From: Kathryn Welch [REDACTED]
Sent: 19 November 2018 13:09
To: Sian Eggington
Subject: RE: Further Information Required on Your Ref: PP-07421588 Our Ref: EP/166/18/HH
Attachments: 18075 DOYLE 100 Sea Road East Preston-02R2 PROPOSED A1.pdf

From: Sian Eggington [REDACTED]
Sent: 15 November 2018 15:28
To: Kathryn Welch
Subject: Further Information Required on Your Ref: PP-07421588 Our Ref: EP/166/18/HH

**Sian Eggington
Planning Team**

PROPOSED FLOOR PLANS 1:50

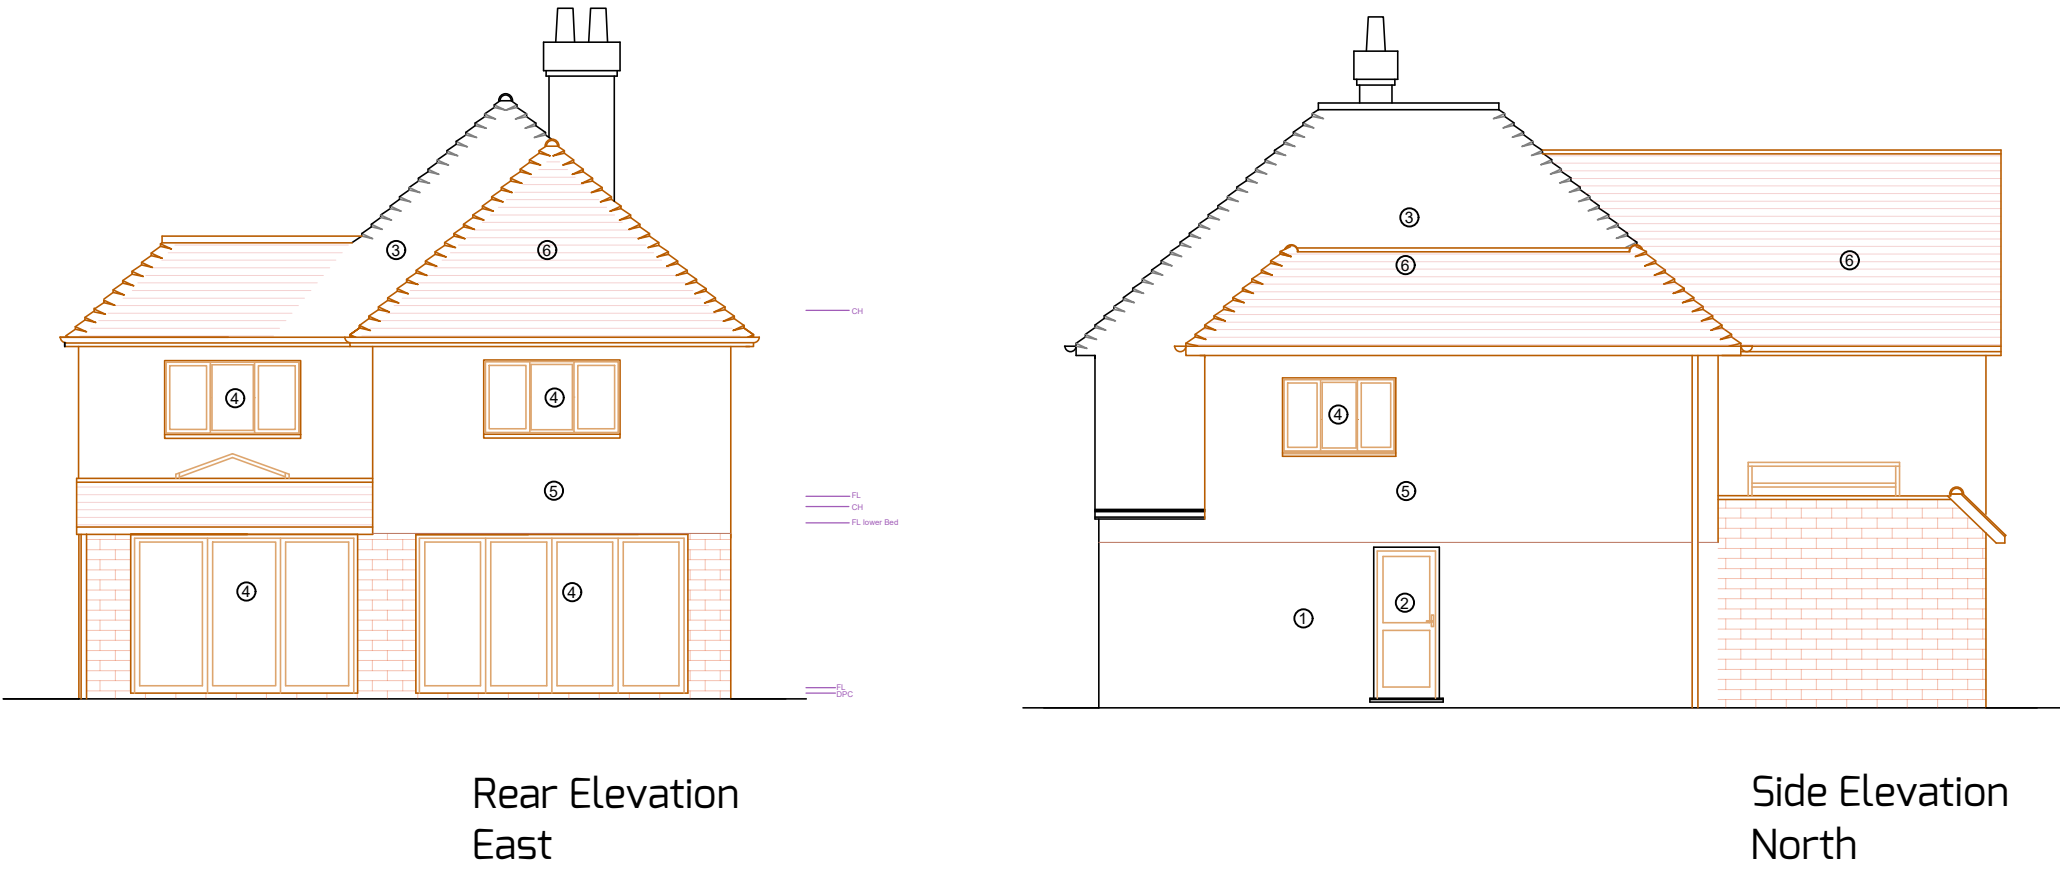
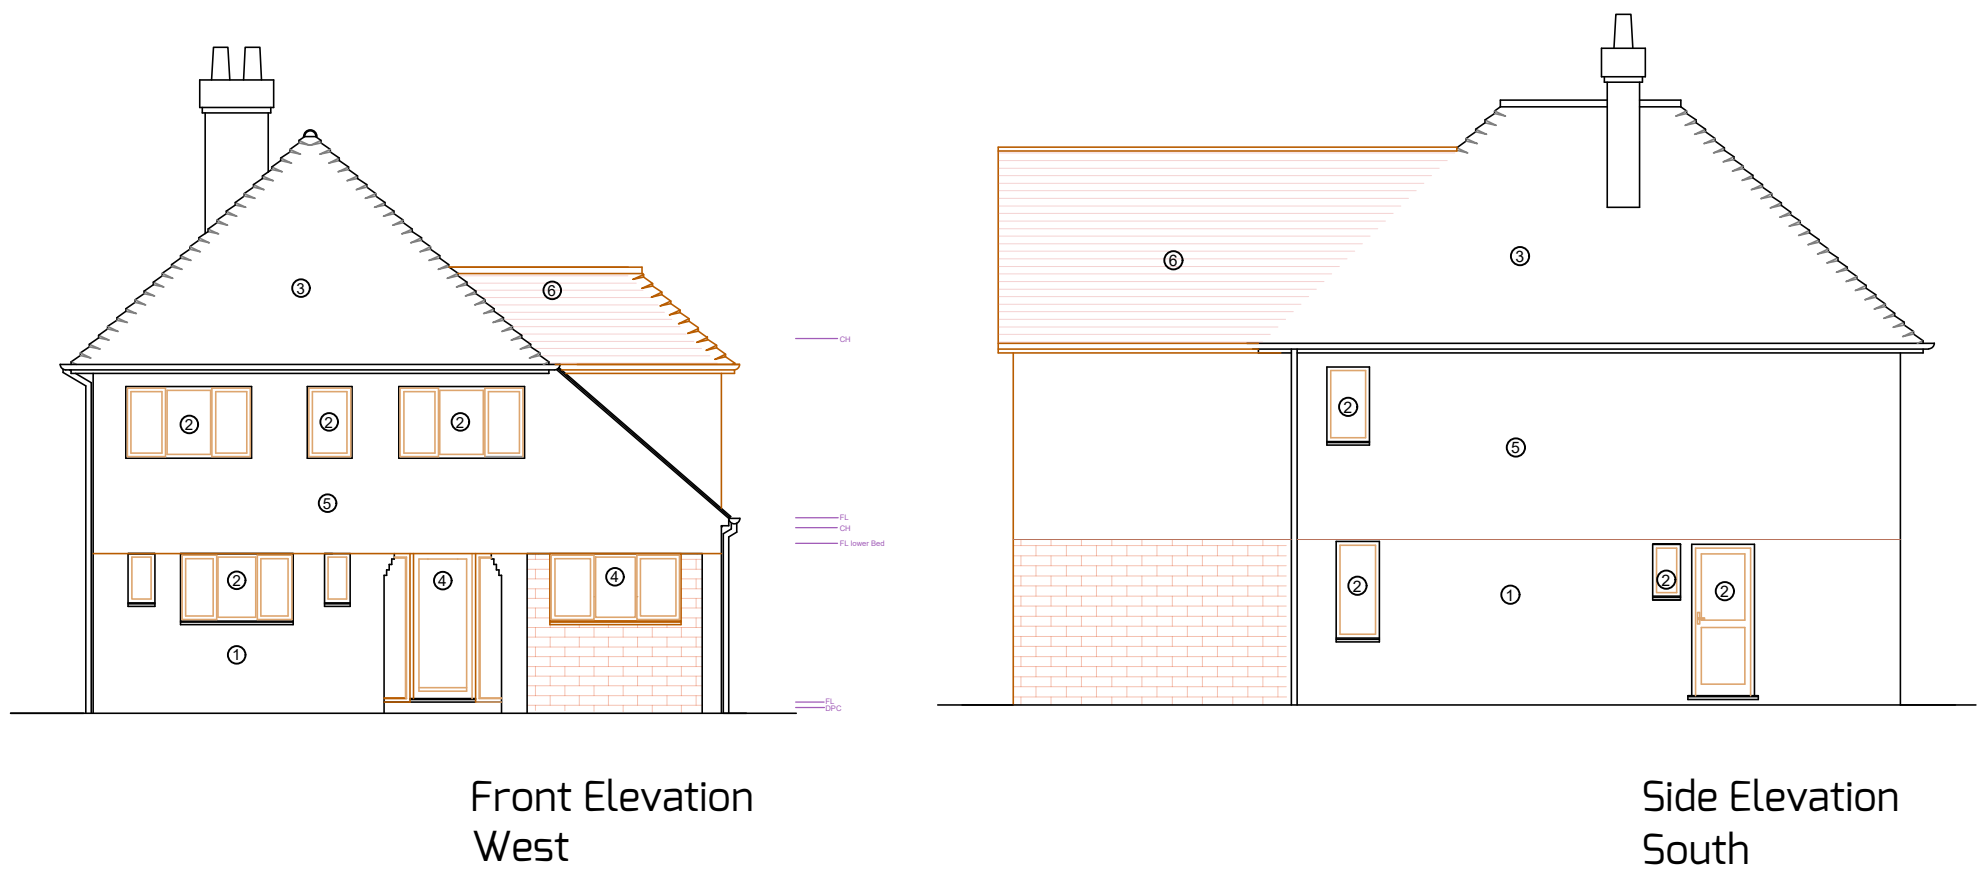
Thank you for your email. Please can a dimension be added on the block plan from the sides of the extension to the side boundaries. Once received I am happy to make the application valid and upload immediately.

Amended plans attached.
